Office of
Environment
& Heritage

Our reference: DOC12/41309; FIL06/2036-09
Contact: Adrian Deville: (02) 6640 2509

Re: Environ Road Quarry Landfill – Draft project approval

## APPENDIX 4 BIODIVERSITY STRATEGY

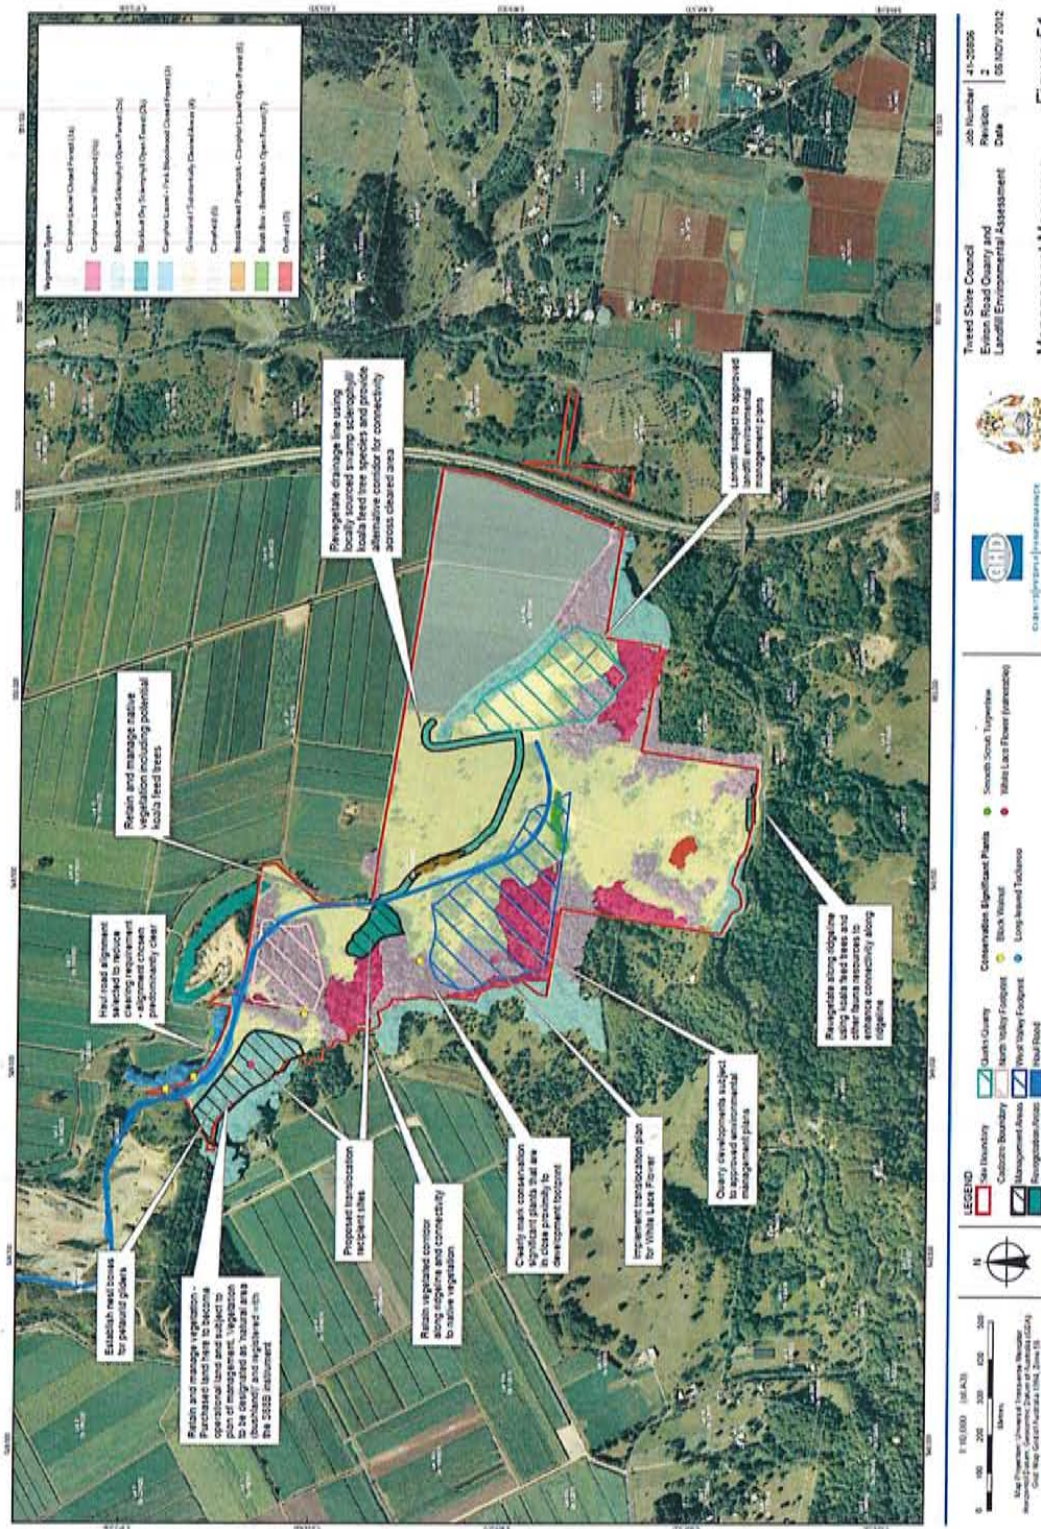
In relation to the available information assessed, there are several elements that may require clarification before OEH recommends that approval is granted. These relate to the significance of the Brush Box – Bennett's Ash community in the West Valley footprint, the provision of low density planting of Koala food trees to the north of the central drainage line (to be rehabilitated) and to details of nest box provision and (as per above) revegetation across the site more broadly.

An area mapped as Vegetation Type 7 – Brush Box – Bennetts Ash (*Lophostemon confertus* – *Flindersia bennettiana*) Open Forest, which is to be cleared from within the West Valley footprint, does not appear to have been given any consideration in terms of the Biodiversity Offset Strategy. This community (about 0.368 Ha) is described in the Tweed Shire Council Report for Eviron Road Quarry and Landfill Ecological Assessment (November 2010 pp68-9) as having moderate to high levels of disturbance. Referring to the Tweed Vegetation Management Strategy, the report suggests that this patch of 'brush box open forest' could be an intermediate stage that may eventually revert to rainforest, but that with high levels of disturbance, lack of structural attributes and a relatively low number of "characteristic lowland rainforest species at this location", it is "not considered to meet the Scientific Committee determination for the lowland rainforest EEC".

OEH has considered the listed species found from the site at upper, mid and lower strata of this disturbed patch of forest. Of the four main species found in each strata (see pp68-9), three are species characteristic of Lowland Rainforest EEC¹. OEH acknowledges that disturbance and structural qualities are important components of EEC description, however, the floristic composition, the existence of patches of Lowland Rainforest elsewhere on the site² and the likelihood that this community is considered likely to revert to rainforest, suggests that this patch of vegetation should be treated as regenerating Lowland Rainforest EEC.

Though it will apparently not be clear until final design stage whether or how much of this vegetation will need to be cleared (pp. 9-118-119 of the EA Vol 1), OEH recommends that the offset strategy should nevertheless be revised to address the above concerns.

The origin and rationale for the proposed low density planting of Koala food trees on the coastal floodplain is unclear, as is the meaning of 'low density'. It is recommended that further information be provided before approval is granted. Subject to that, Koala food tree offsetting should be undertaken strategically in relation to this area in a manner likely to yield a self-sustaining natural ecosystem on the floodplain while maximising Koala movement and habitat value in the context of the broader site and landscape.

It is not clear from the information provided how many nest boxes would be provided and where they would be located. OEH recommends that these details be provided before approval is granted.
